# CITY OF ALBUQUERQUE

**Re: Weck's Restaurant, 10131 Coors Blvd NW**  
**Request for Certificate of Occupancy- Transportation Development**  
Engineer's Stamp dated 10-31-16 (B14D001)  
Certification dated 6-7-17

**Re: Weck's Restaurant**  
**10131 Coors Blvd NW**  
**60-Day Temporary Certificate of Occupancy- Transportation Development**  
Engineer's Stamp dated 10-31-16 (B14D001)  
Certification dated 6-7-17

SHEET TITLE
Site Plan (Traffic Circulation Layout)

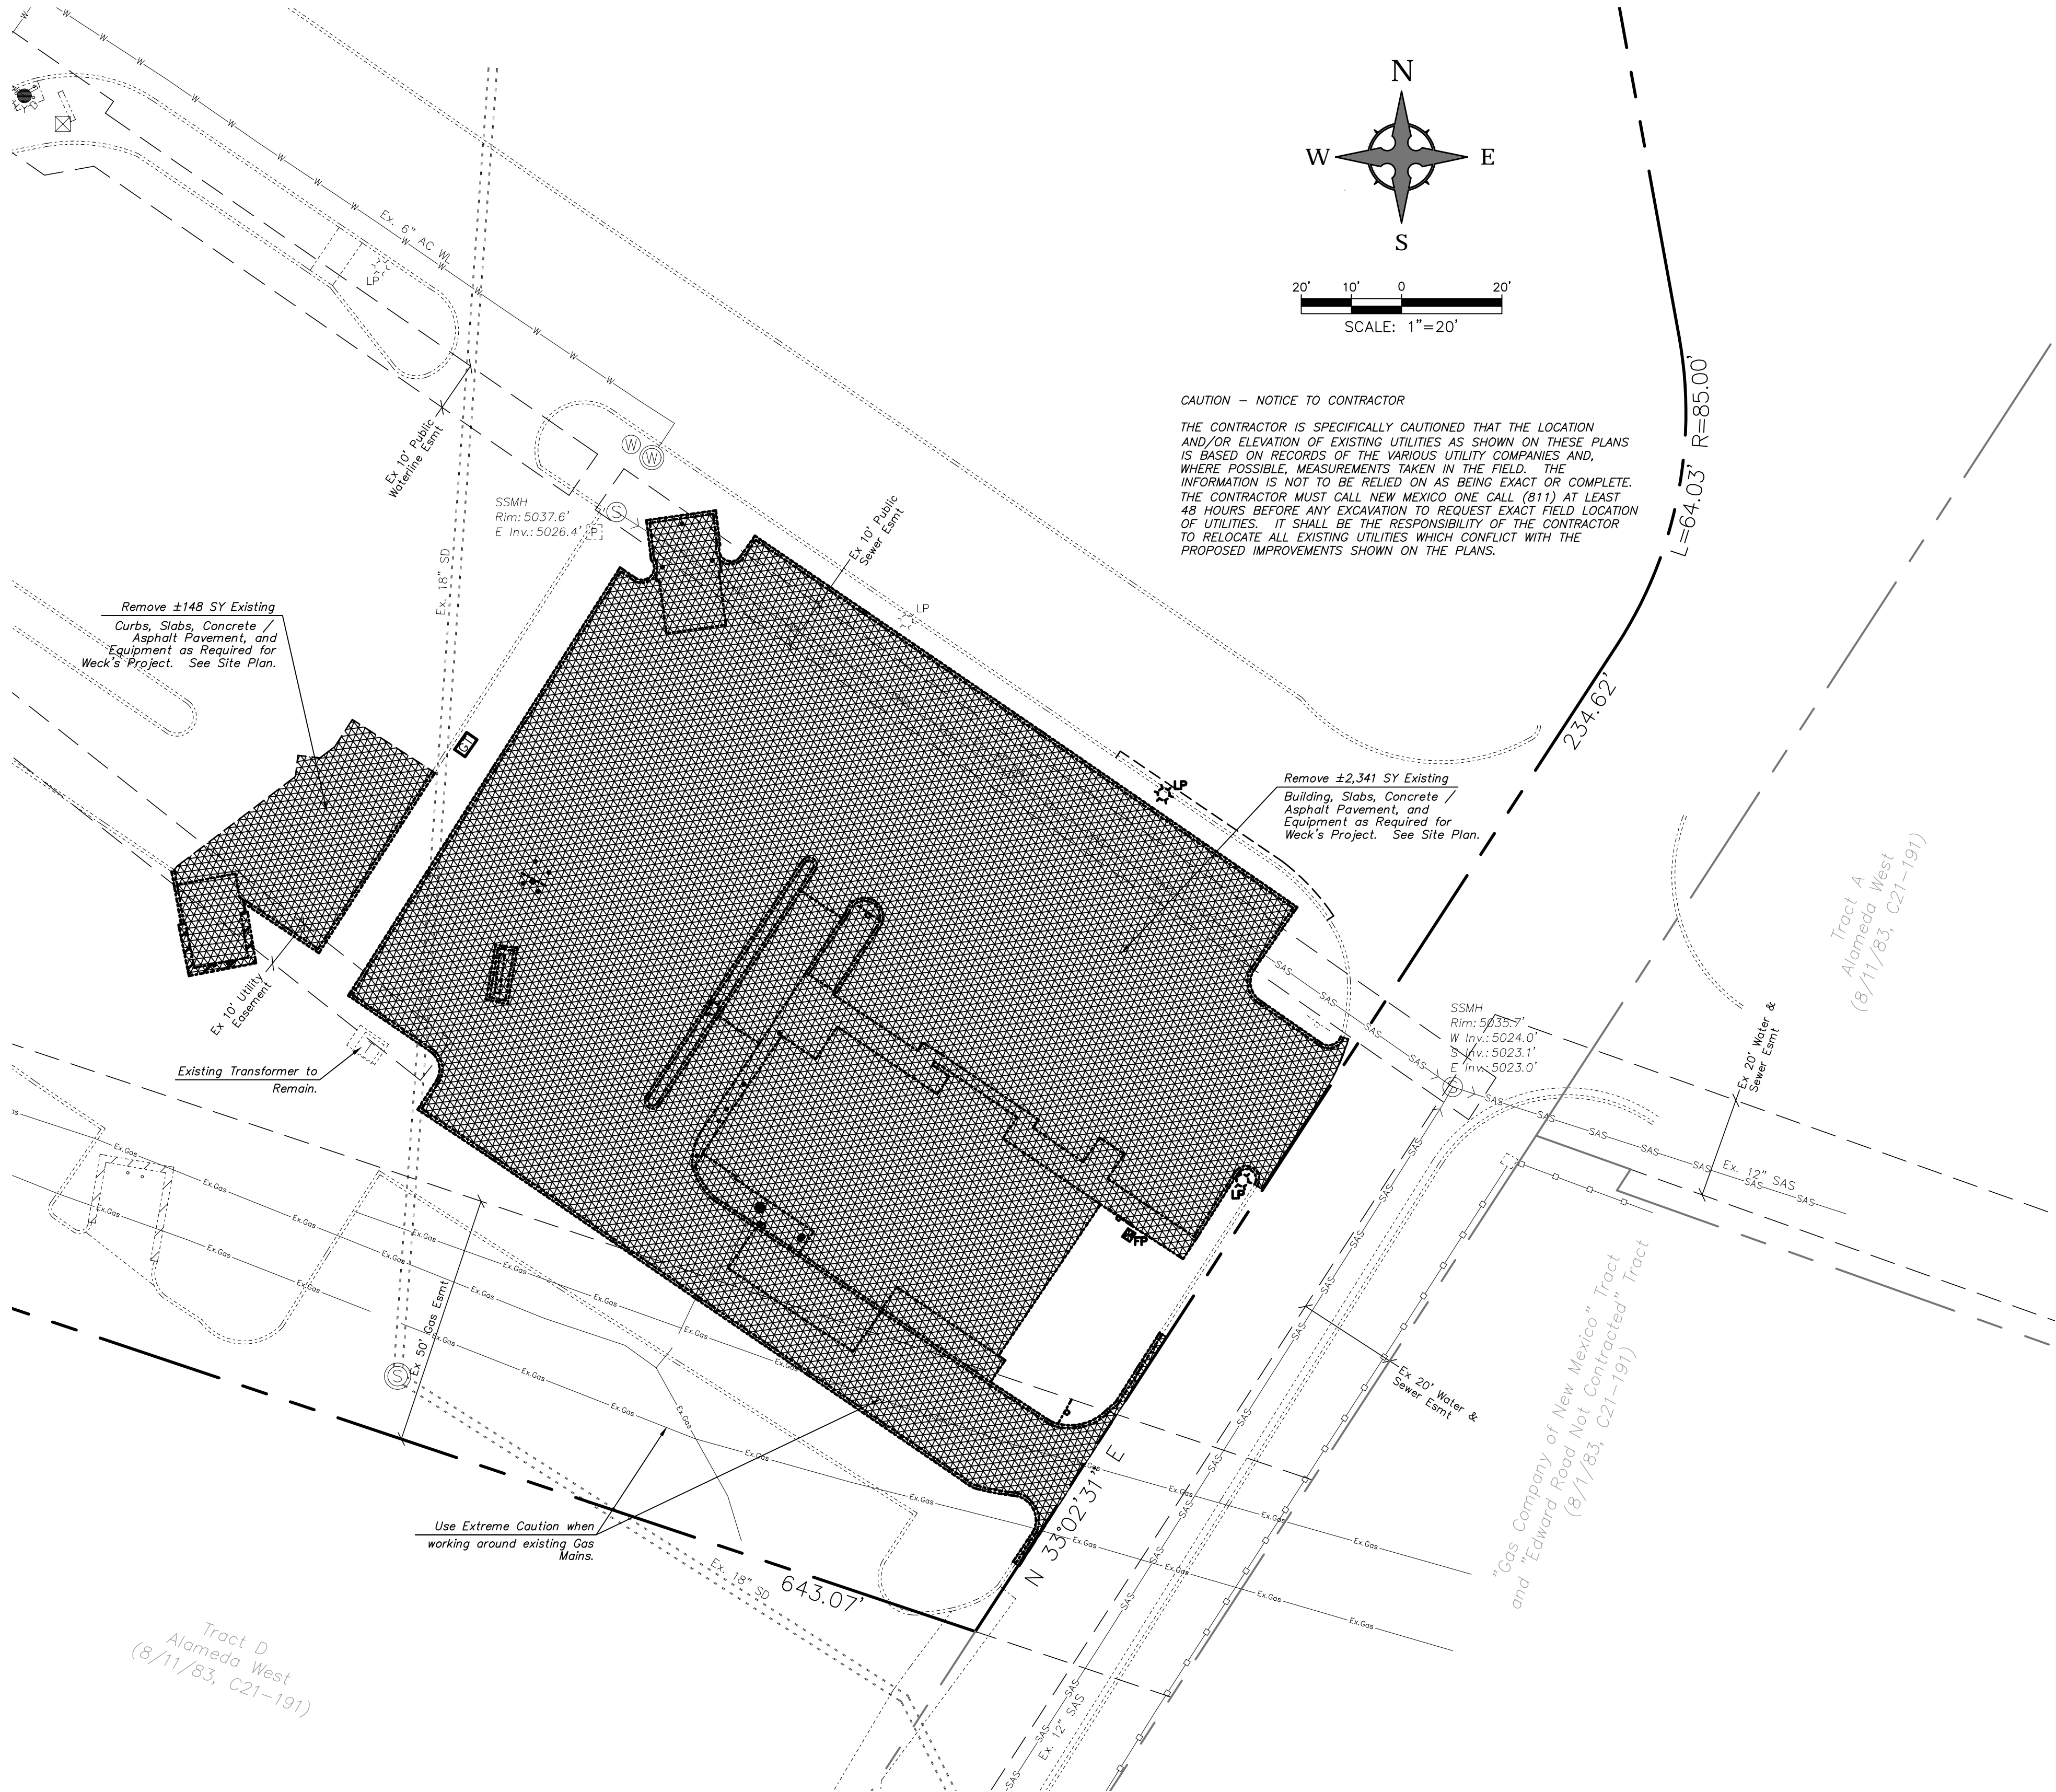
1. Remove all parking bumpers along south west side of the building. Parking spaces should be 18' in length.
2. A stop sing is required at south east exit.
